REF: 21/02083/REM

**Location: Land at Tappers Farm Oxford Road Bodicote**  
**Holding Objection**

Proposed planning layout 0737-102

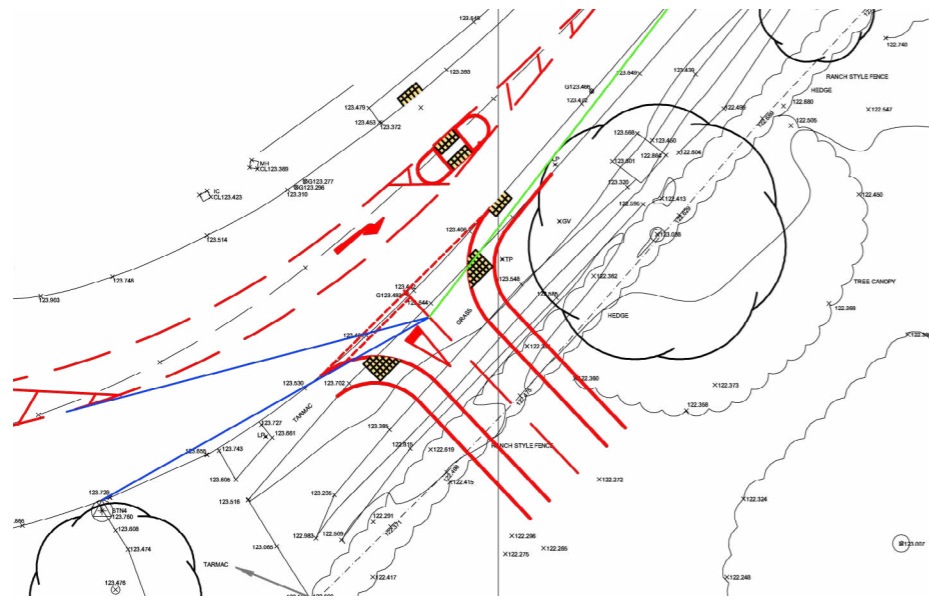
- There is an area of ambiguous green space alongside the parking for plot 27. There is also a lack of surveillance over this space due to a single ground floor obscured window being provided. I recommend this space is brought within the ownership of this plot with suitable landscaping and boundary treatments introduced to demarcate the change from public to private space. Additionally, I ask that an additional window is added to the side elevation overlooking the parking spaces from the living room.

- The parking arrangement for plots 22-25 leave them vulnerable, with many side and rear boundaries easily accessible whilst being shielded from sufficient surveillance by boundary treatments. The rear and side boundary is the entry point for the vast majority of residential burglaries, and as such it is imperative that they are protected by being enclosed within a secure perimeter block, or by being well overlooked by surveillance and protected with defensible space and planting. I would recommend this area is reconfigured to locate parking in areas where the space is well overlooked by surveillance from the dwelling they serve, and where side and rear boundaries are enclosed or protected by defensible space and planting.

- An additional window should be added to the kitchen, over the sink of plot 41 to address the blank gable end and lack of surveillance overlooking the parking at present.

- The parking for plot 44 is vulnerable, located out of sight of the plot and lacking surveillance. I recommend an additional window is added to this plot, or the front facing window being a bay window, to increase surveillance over the parking.

- The garage and parking spaces for plot 43 are particularly vulnerable to crime, as they are located directly adjacent to a public footpath whilst being shielded from view by the boundary treatment enclosing the rear garden of the plot. I recommend the 1.8m close board fence alongside the driveway is removed, and the rear garden access gate relocated between the garage and house to open up views from the dwelling. Additional defensible space and planting in the form of hedging should be provided alongside the knee rail to provide further separation from the private parking spaces and the public footpath;

- Additional defensible space and planting to a depth of 1m should be provided alongside the boundary wall of plot 42 which faces the POS, to clearly mark and define the change from public to private realm.
- Defensible space and planting should be provided wherever parking adjoins a boundary wall (plot 40/44 for example), again to demarcate the change from public to private space, and to provide sufficient standoff to prevent vehicles being used as a climbing aid to gain access to the rear garden.
